Your ref:  
Our ref: 22/02046/F  
Please ask for: Mrs Lesley Raby  
Direct dial: 01553 616818  
E-mail: borough.planning@west-norfolk.gov.uk

Details: **Proposed single storey extension to dwelling at East & West Rudham Pre School Group School Road East Rudham King's Lynn Norfolk**

EXISTING ROOF PLAN
Scale: 1:100

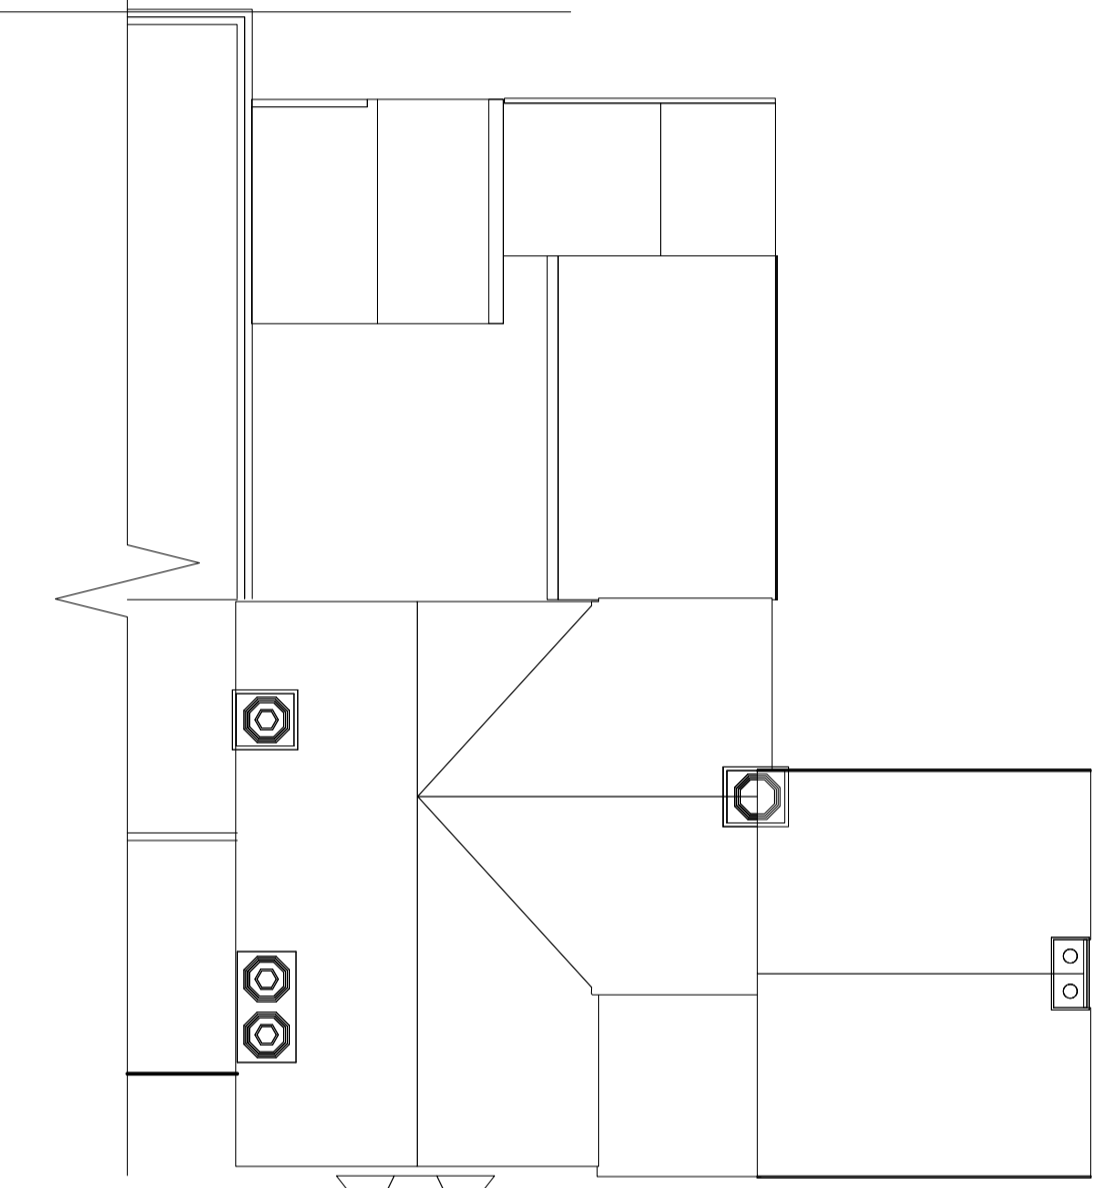
1. Provide an existing and proposed roof plan. Are the roof lights flat or are they lantern lights, if so they are not shown on the elevations.
2. Confirm that the site levels remain unchanged.
